From: Contact Centre (CRM) <contact@ribblevalley.gov.uk>
Sent: 13 May 2026 15:53
To: Planning
Subject: Planning Application Comments - 3/2025/0922 FS-Case-837532235

Planning Application Reference No.: 3/2025/0922

Address of Development: Land adjacent Tithe Barn Cottages Pendleton Road Wiswell BB7 9BZ

TO HAVE MECHANICAL EXTRACT OF 15 LITRES PER SECOND, LINKED TO LIGHT SWITCH WITH 15 MINUTE OVER RUN TO HAVE AN AIR INLET INTO THE ROOM E.G. 10MM GAP BENEATH THE DOOR.

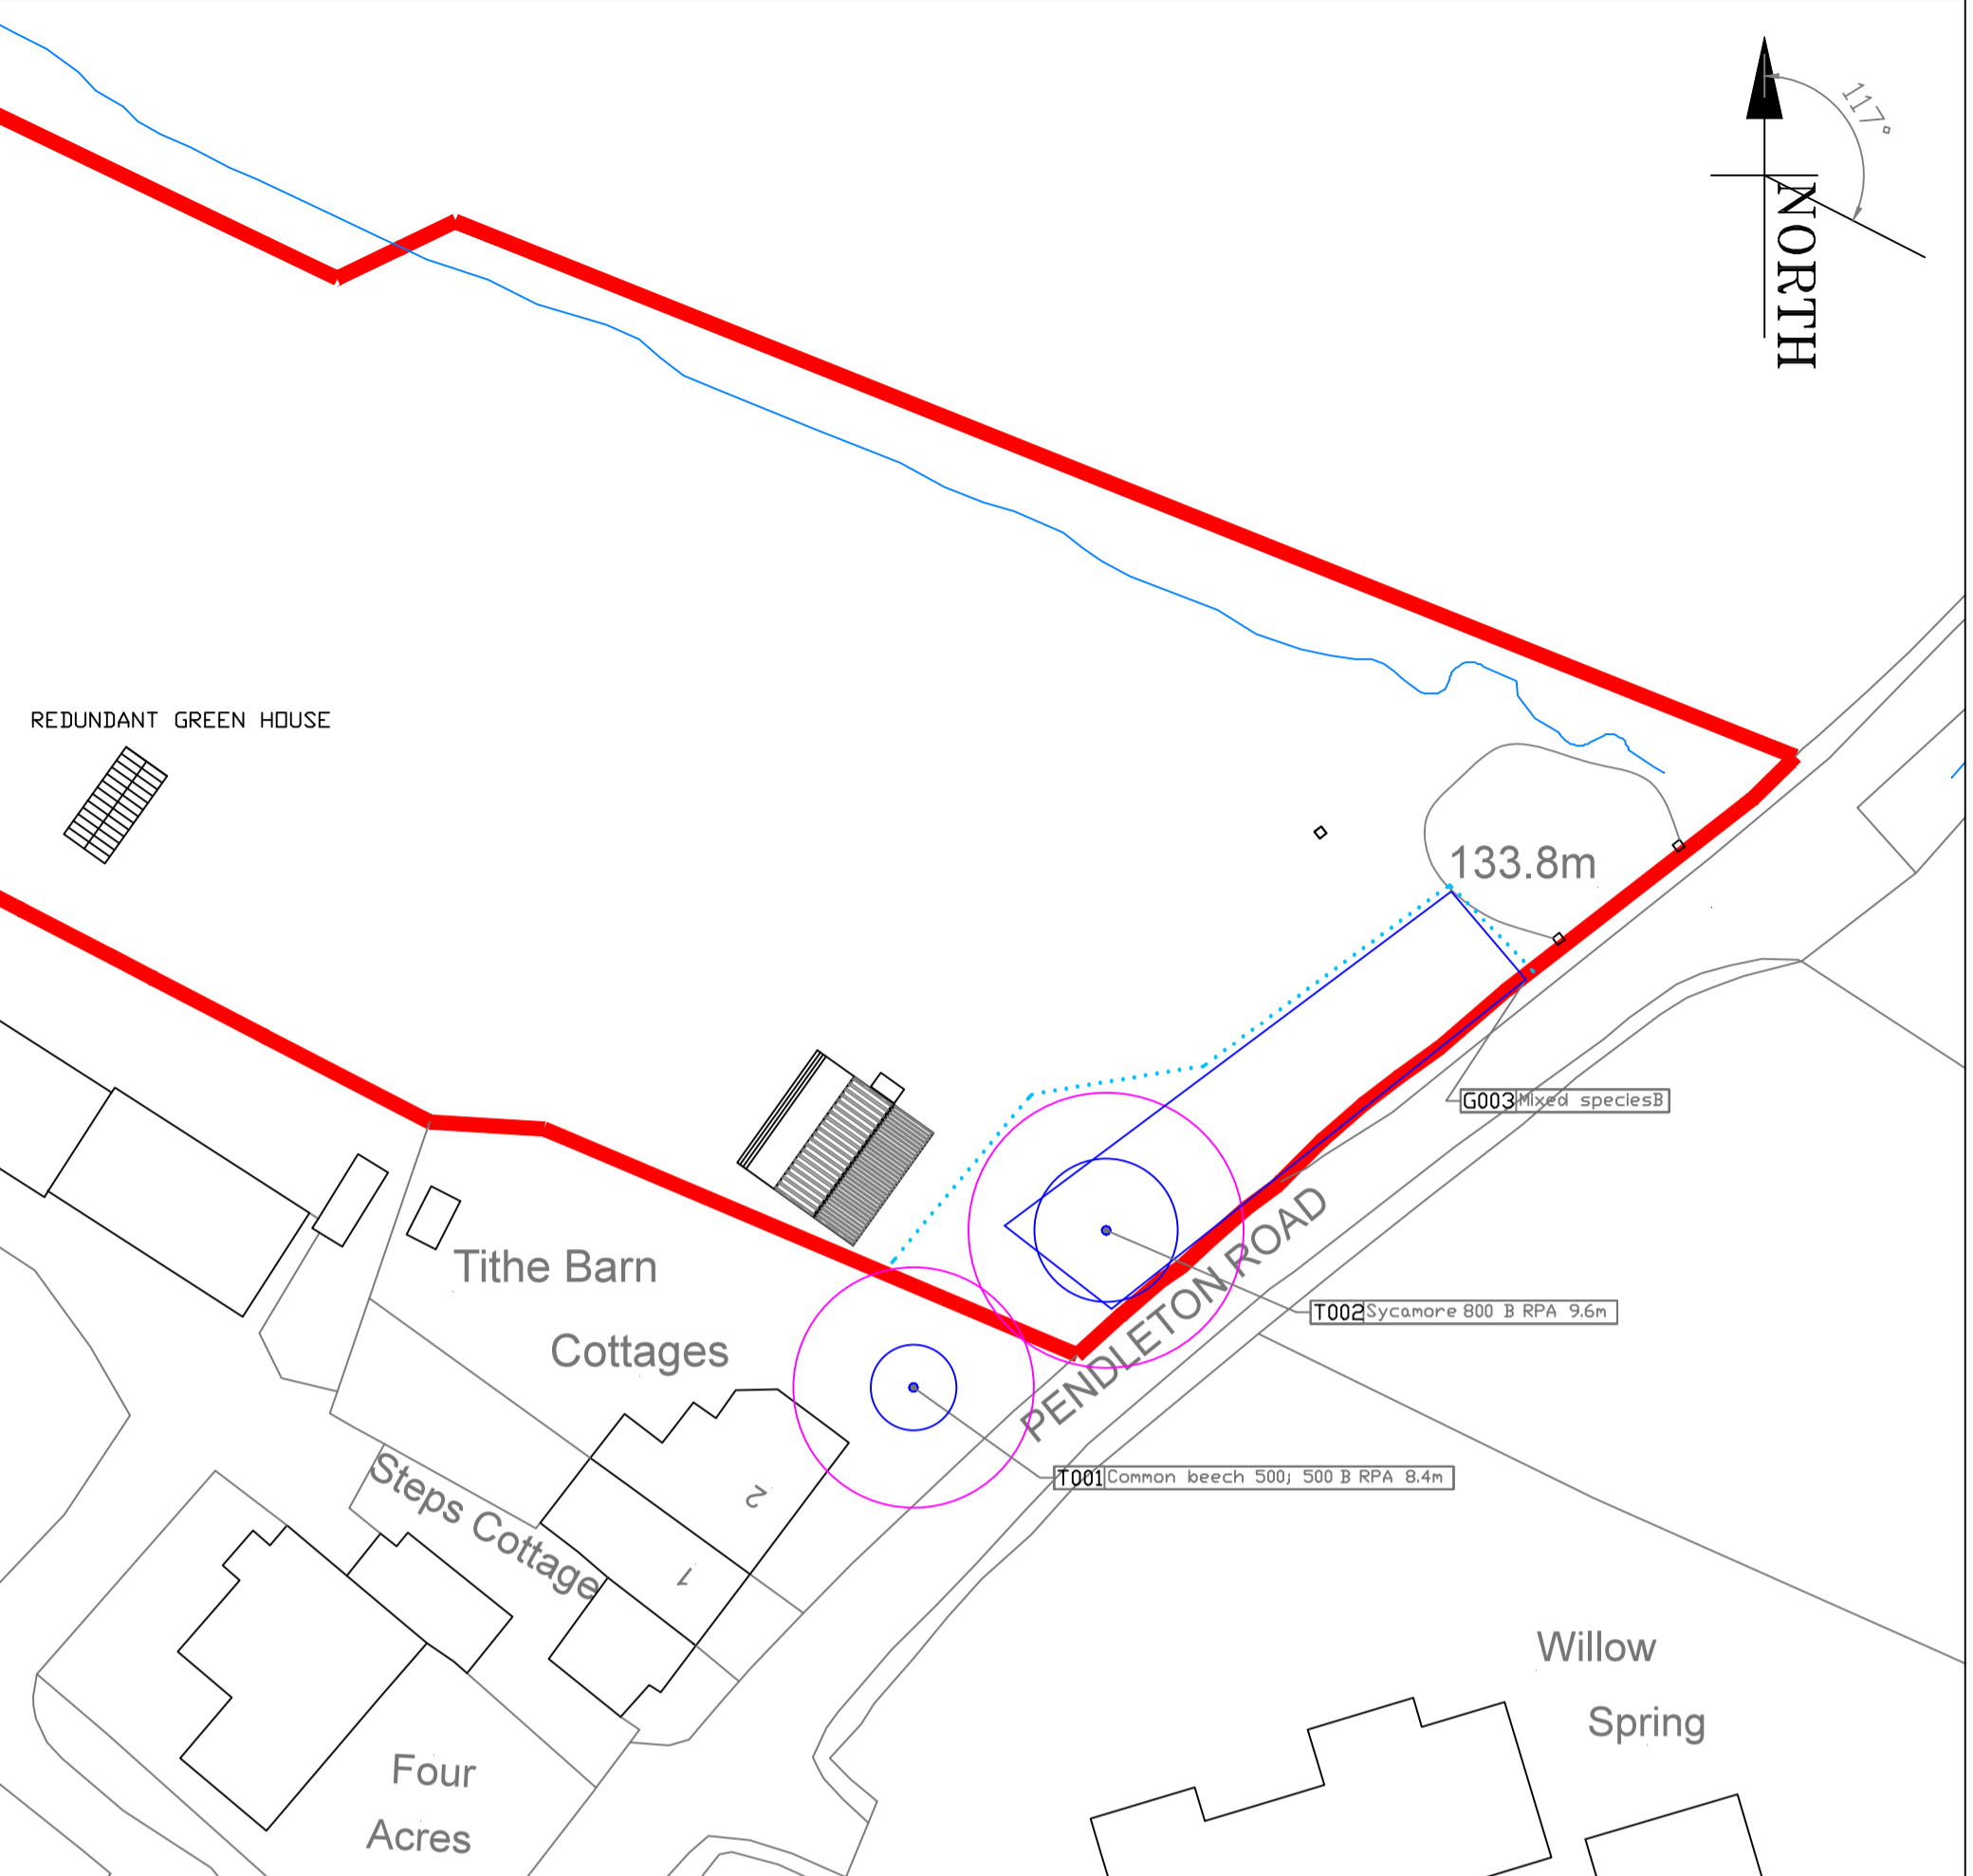
I am also highly sceptical that the existing wooden shed could structurally support the extent of works proposed, including a tiled roof and a full solar panel array, without substantial rebuilding and reinforcement. This calls into question whether this can genuinely be described as a "conversion" at all. In reality, the proposal appears far closer to the construction of a new dwelling under the guise of converting an existing structure.

The original planning application for this was rejected and these new plans don't offer any substantial changes therefore all of the original objections remain the same. There are only 3 small points of change that I can see. One is to add a window, another is to use stone on the building and the final one is to enter and exit the site in a forward movement. On the third point this is only possible due to the landowner previously having the grassed area replaced with hardcore. This harms the natural biodiversity of the land. In the transport statement it also mentions that visibility needs to be made greater. Their stated intention is to cut back the hedging alongside the lane. This changes the environment and appearance of the area.
